Back to Front Exterior Design
Wey Court West
Union Road
Farnham
GU9 7PT

Please ask for: Ms Iqraa Malik
Email: iqraa.malik@terraquest.co.uk
Telephone: 0121 234 1390
Our Ref: R/279/21/HH
Your Ref:
Date: 12th November 2021

Application for Planning Permission for Works or Extension to a Dwelling

Development: Erection of single storey rear extension, conversion of garage to habitable use, extend existing front porch, new pitched roof over existing front flat roof and alterations to fenestration/openings.

18 SITE PLAN 1:200

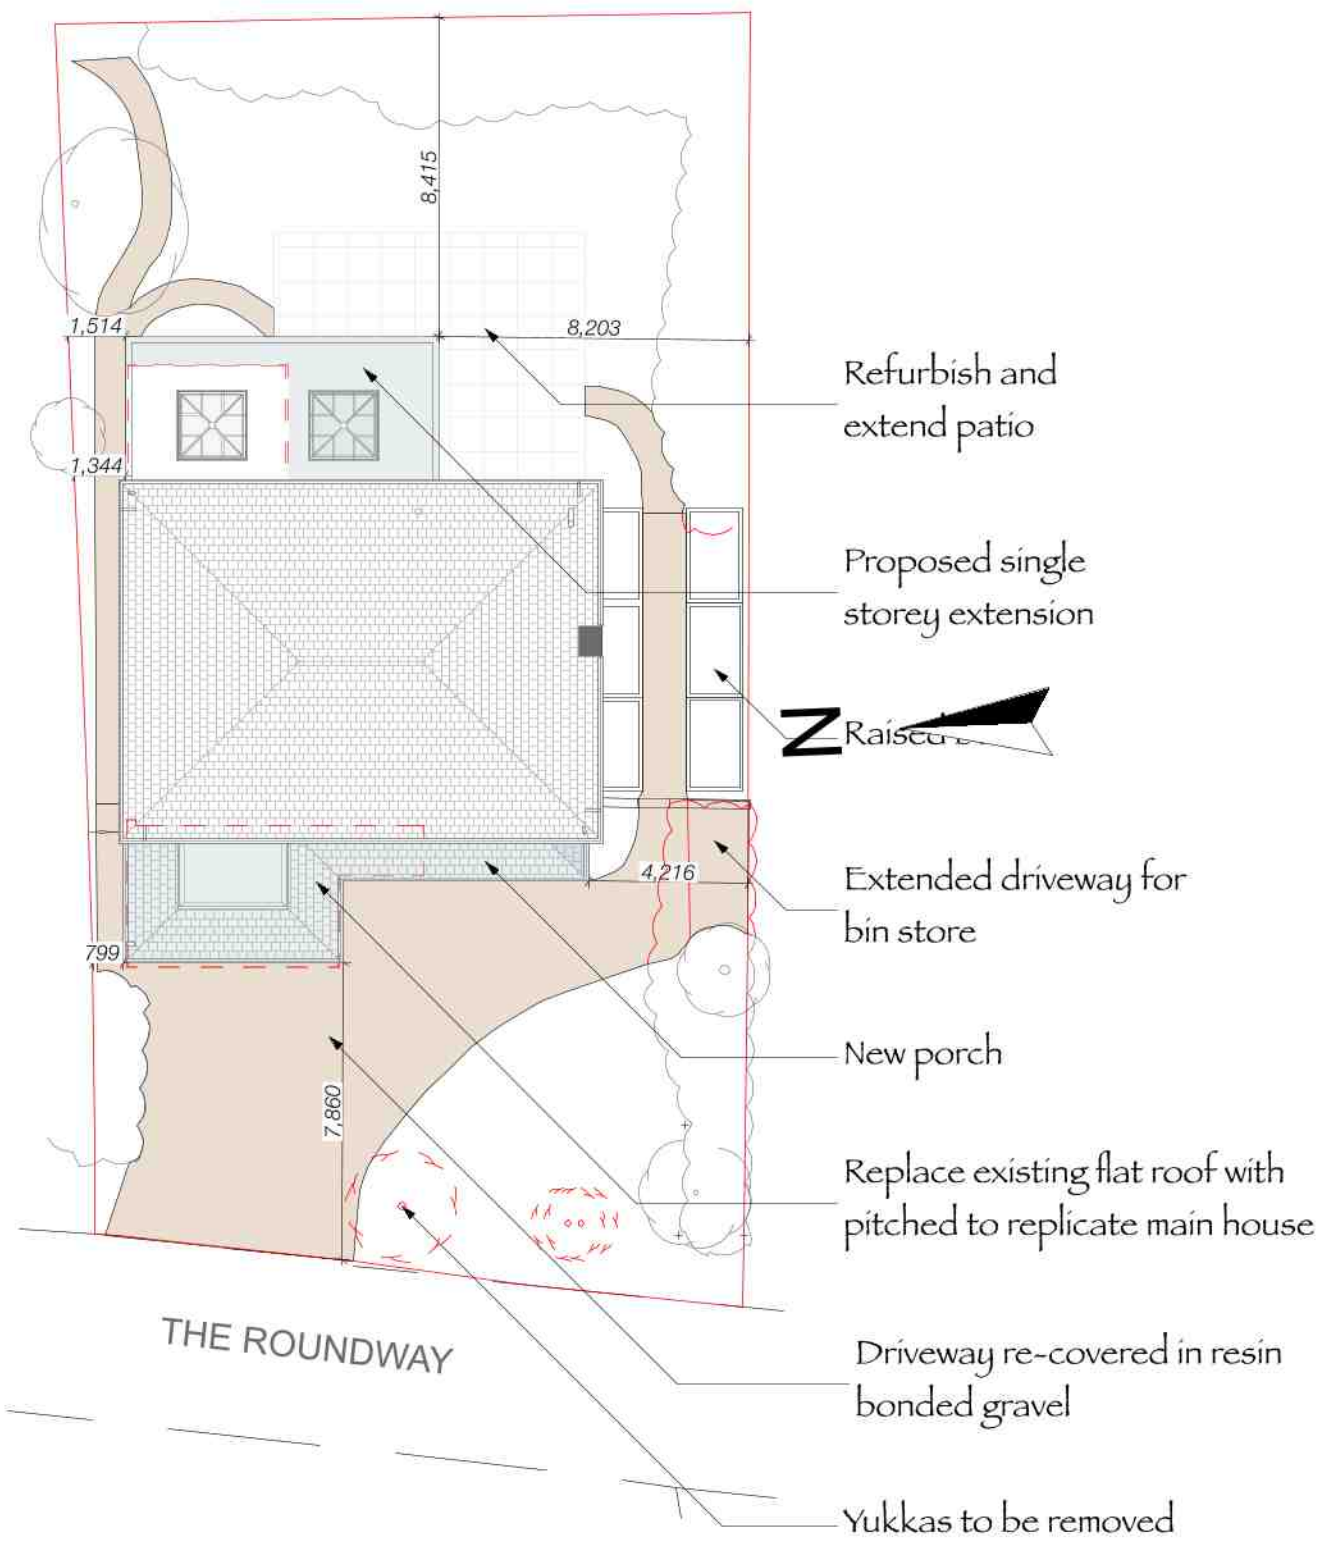
Please submit a block plan with dimensions from the proposed extension(s) to all site boundaries at a scale of 1:500. Further details of what must be included on the plan can be found in the Validation Requirements List.
